App no: 23.0770

Address: 1 Bonny Grass Terrace Billington

Proposal: Proposed reconfiguration of first floor accommodation and installation of new external staircase to provide access to first floor apartment. Removal of ground floor side door opening and extension of retail area into current lobby, stairwell, toilet and office area

PROPOSED GROUND FLOOR PLAN

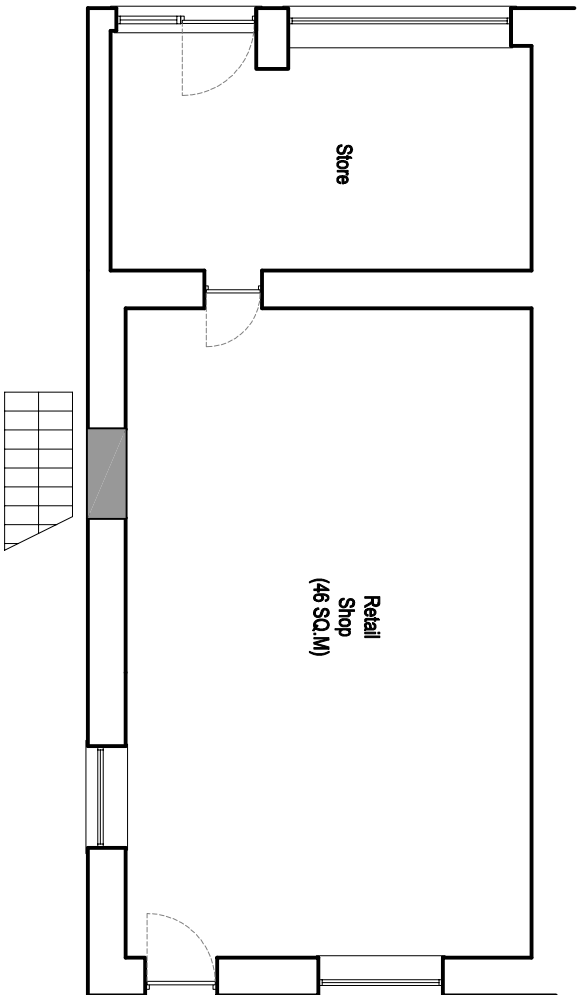
The erection of the external staircase over the footway will be detrimental to pedestrian movements along the side street of 1 Bonny Grass Terrace. The side street links to Billington Gardens via a ginnel.

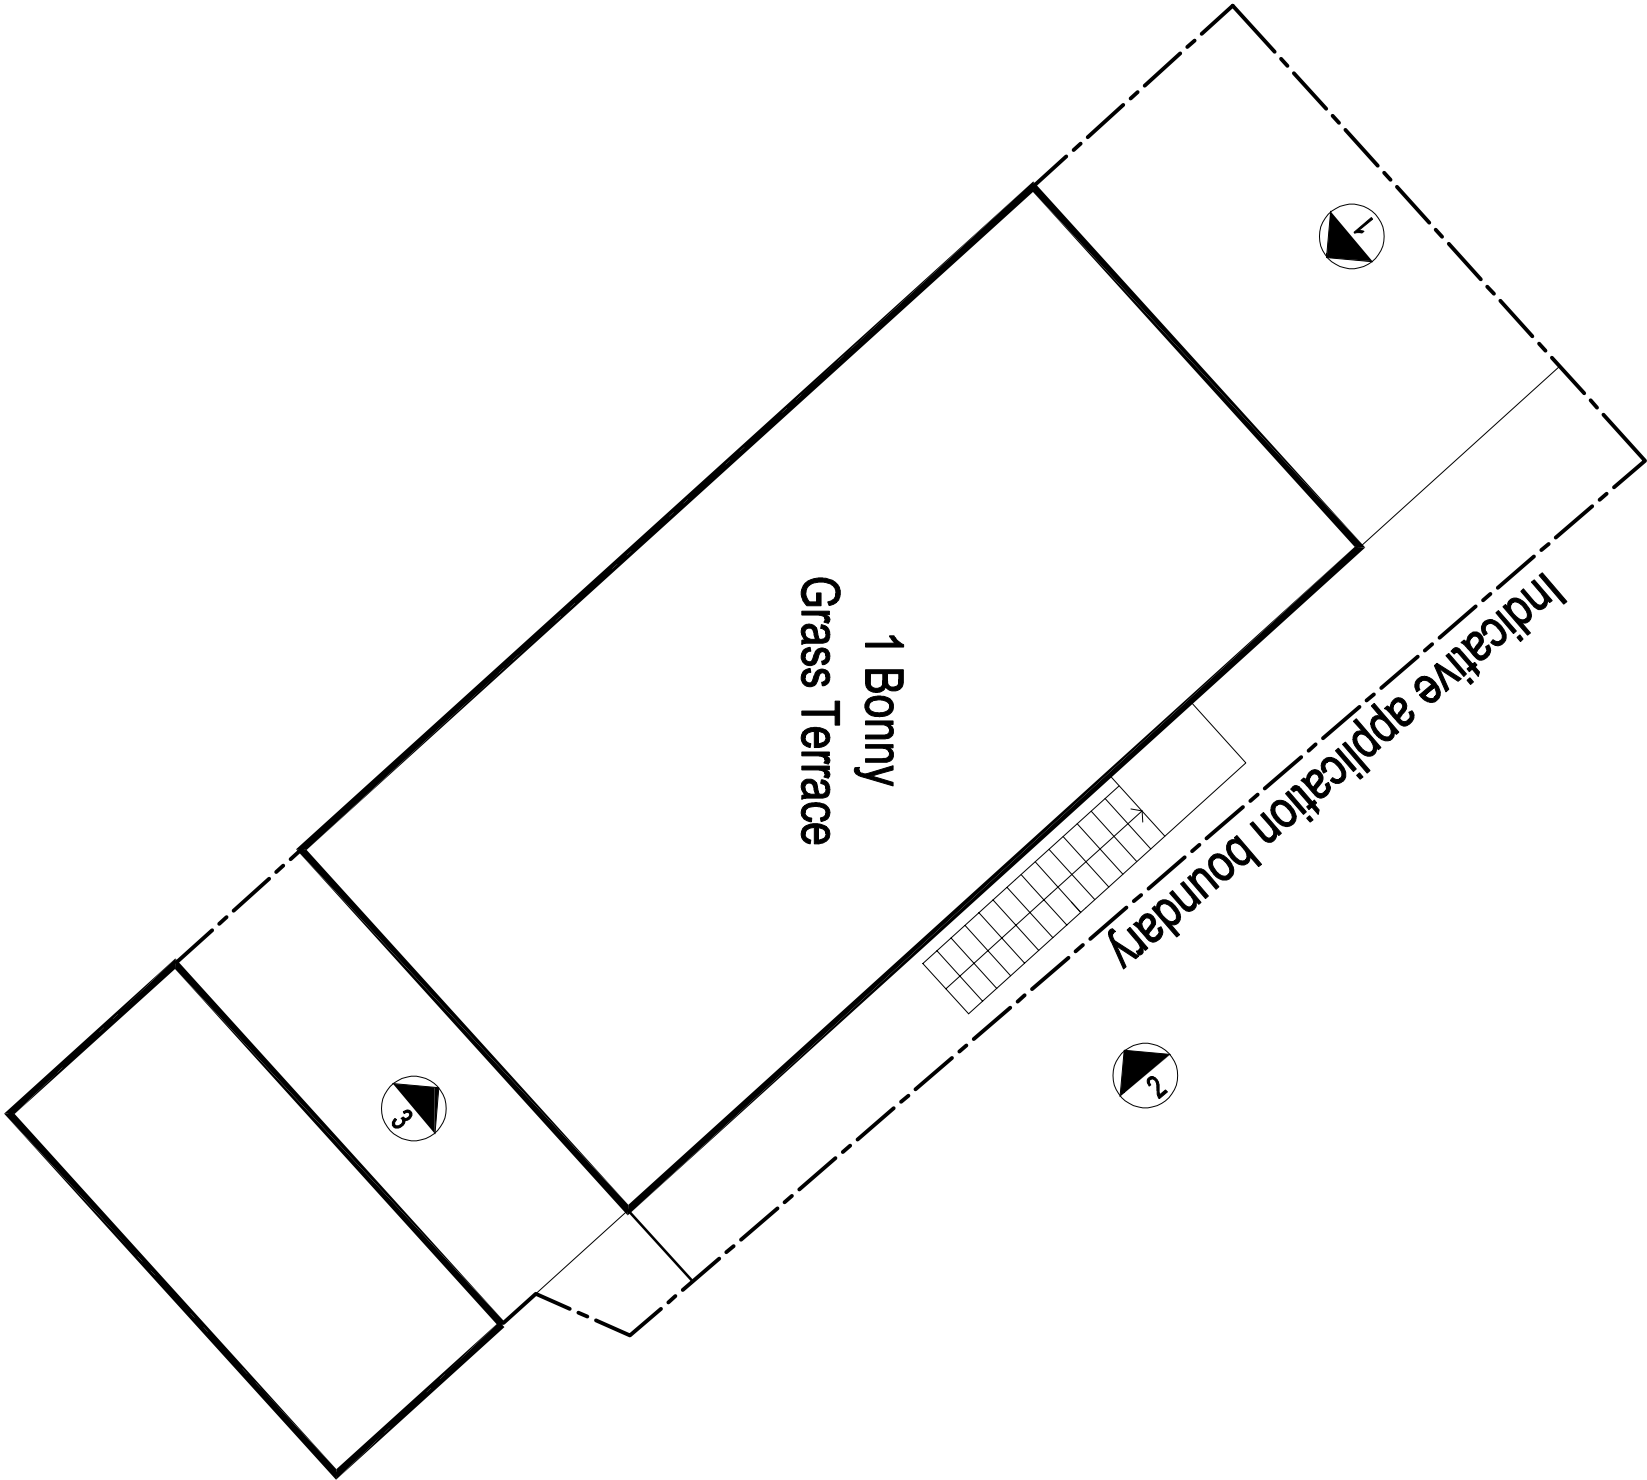
The proposed external staircase will lie on land which the applicant does not own and forms part of a footway. The application form states that the ownership of the land is unknown and that an advertisement has been placed in the Lancashire Evening Telegraph on 04/10/2023.

Lancashire County Council acting as the Highway Authority would raise an objection regarding the proposed development and are of the opinion that the proposed development will not have a significant impact on highway safety, capacity or amenity in the immediate vicinity of the site.
